## WEST SUSSEX COUNTY COUNCIL CONSULTATION

| <b>LOCATION:</b>                | Rookery Park<br>New Barn Lane<br>North Bersted<br>PO21 5DN                                                                                                  |
| <b>SUBJECT:</b>                 | BE/162/21/DOC<br>Approval of details reserved by condition imposed under BE/103/19/RES relating to condition 5-footpath linking site with Winston Crescent. |
| <b>RECOMMENDATION:</b>          | No Objection                                                                                                                                                |

Footway/Cycleway
Type 1 & 2

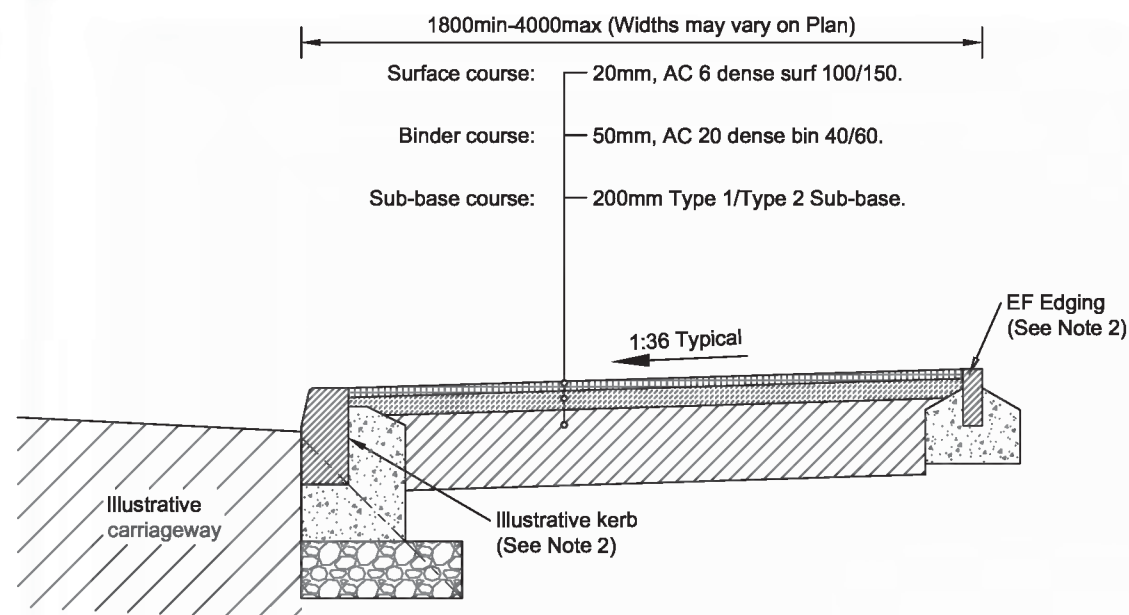
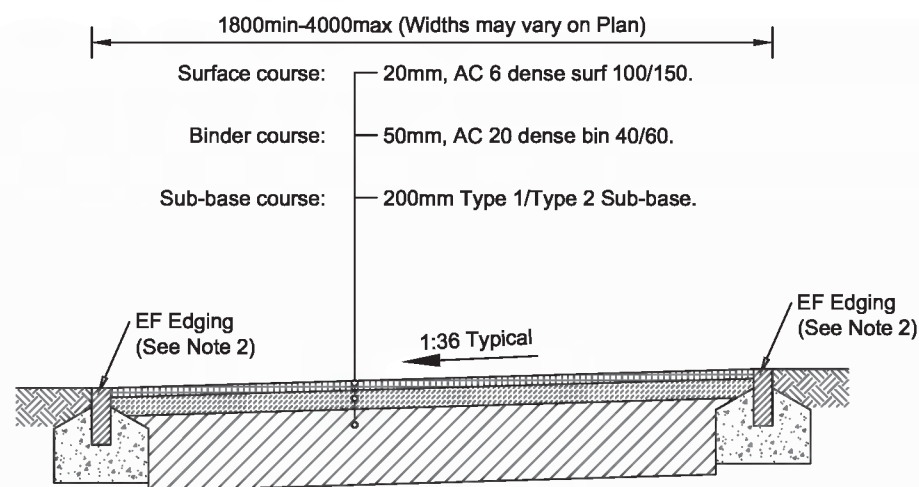
The plans show the extent of the footway (on-plot) from the site which links into a new footway within the public highway on Winston Crescent. This provide access into the Jubilee Playing field.

1643-WSP-HKF-NBL-DR-C-0700

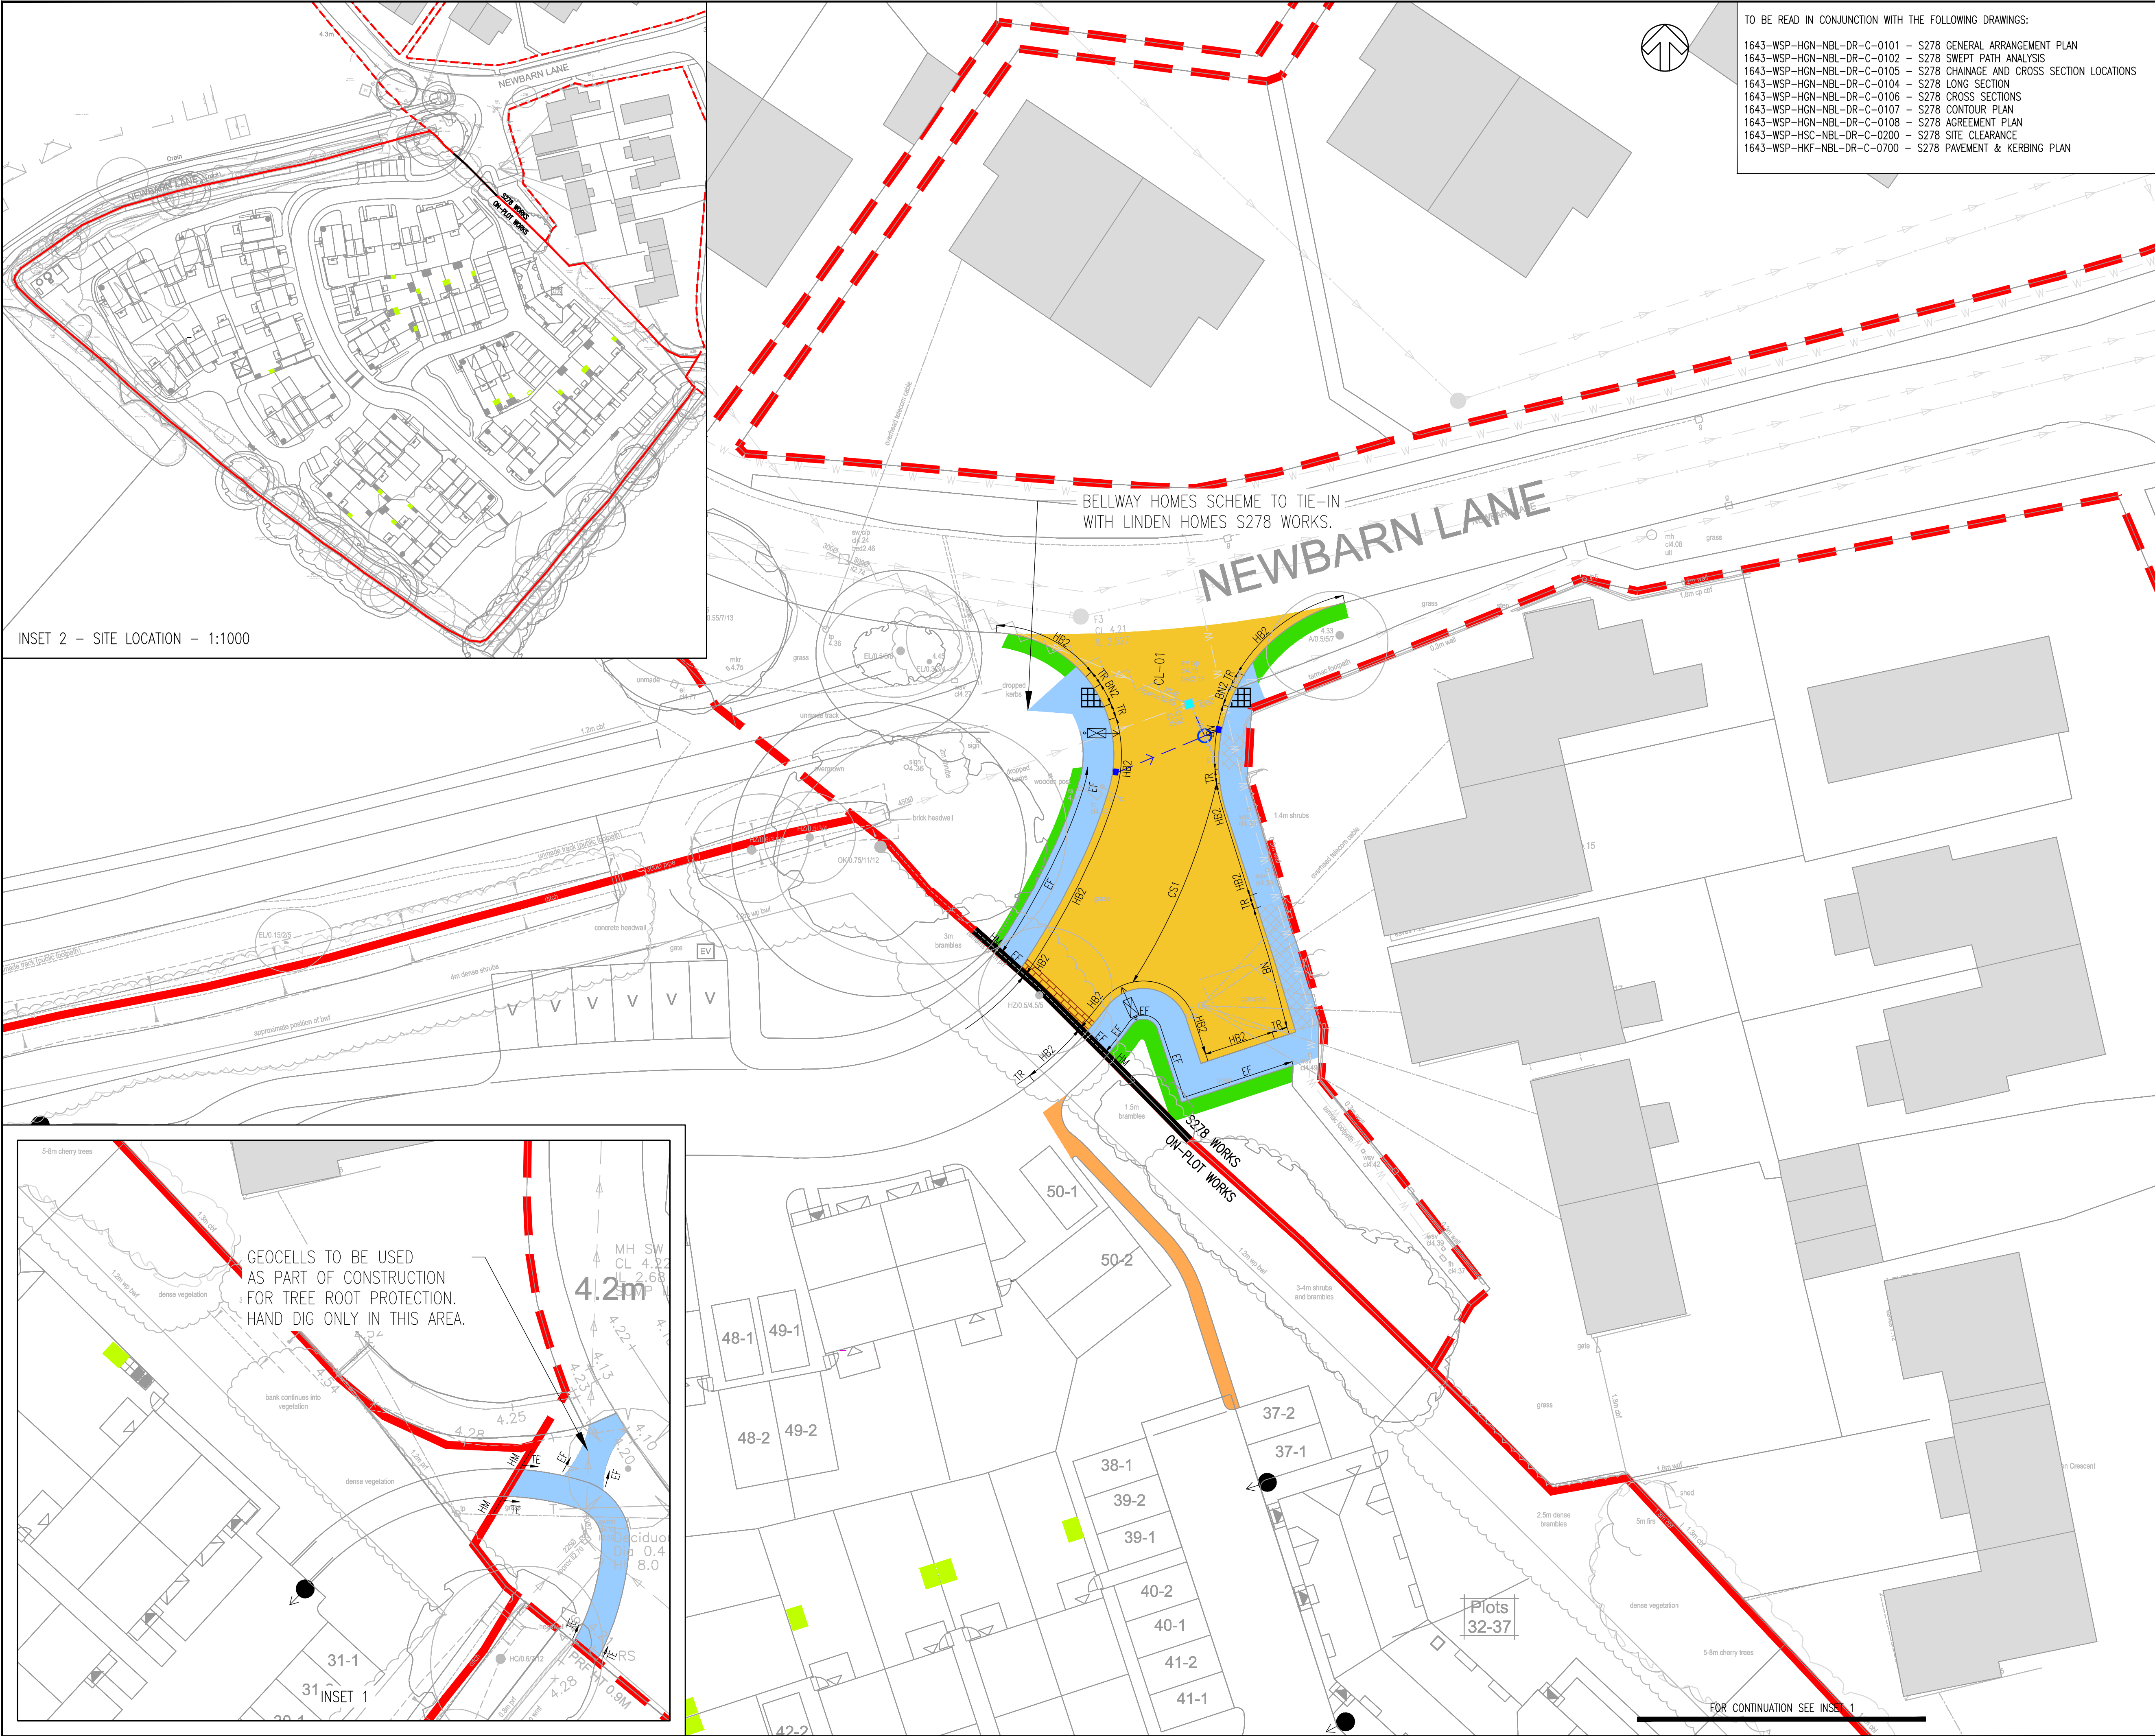
The schedule of works should be complete by 30th July 2022 to coincide with the footway works on-plot to provide a continuous link into and out of the site.

The path also links into the existing footway on Winston Crescent providing access on foot to the existing public footway network.
